Subject: RE: Yapton SD7 Design Code Submission refs Y/40/20/DOC & Y/41/20/DOC

Subject: Yapton SD7 Design Code Submission refs Y/40/20/DOC & Y/41/20/DOC

Indicative illustrations of Village Street

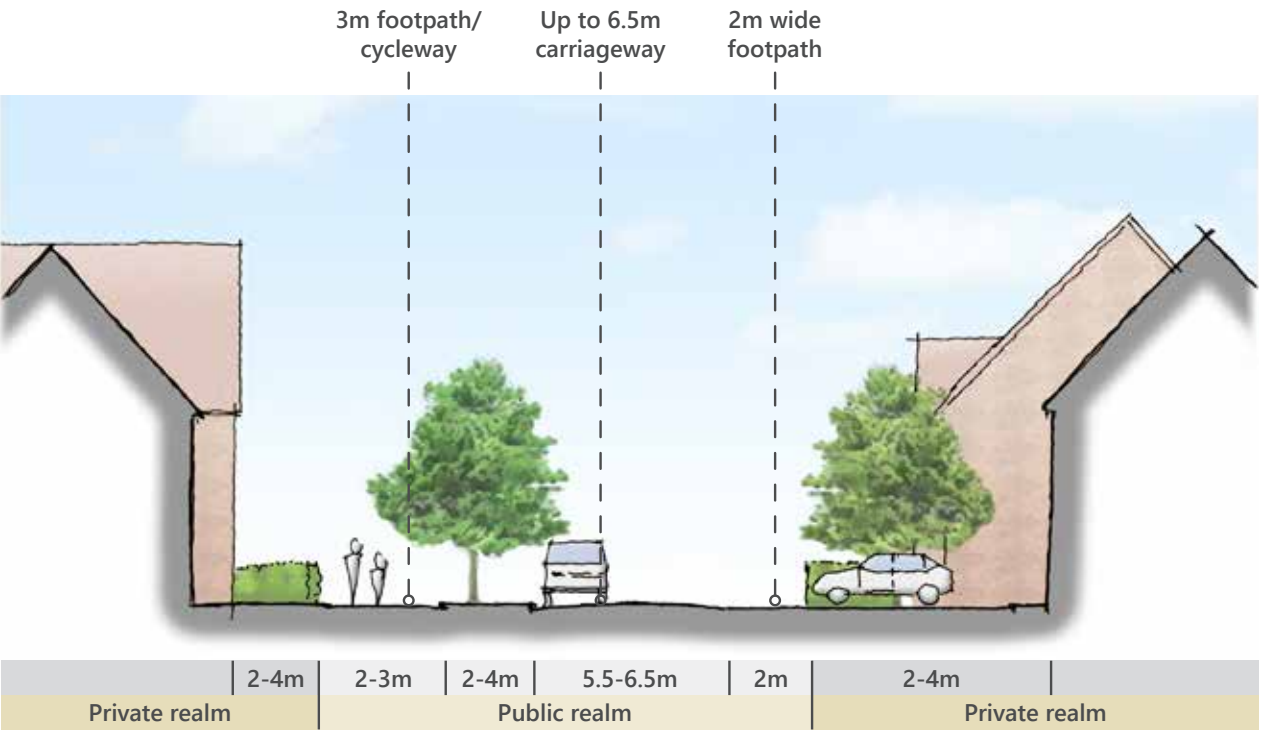
On point 9, we are looking for some more detailed parameters of where village street verges will be narrow and where they will be wider – and what the total width might be. You state on page 20 that “2m min verge width on both sides of carriageway where appropriate to setting.” Can you be more specific what you mean by setting.

- (8) We don't consider frontage parking to be appropriate on the main village street.
We will update the plans to remove frontage parking.
- (9) The Code says that verges either side of the main village street will be 2m on both sides but 'as appropriate to setting'. This creates ambiguity. It would be better to add to this to clarify where verged will be wider or narrower whatever the case may be. It is also noted that the Outline D&A referred to 6-10m verges in these areas.

On point 9 please can you provide clarity on what you are looking for here as the access and movement section of the Design Code Masterplan does provide clear reference to footways etc.
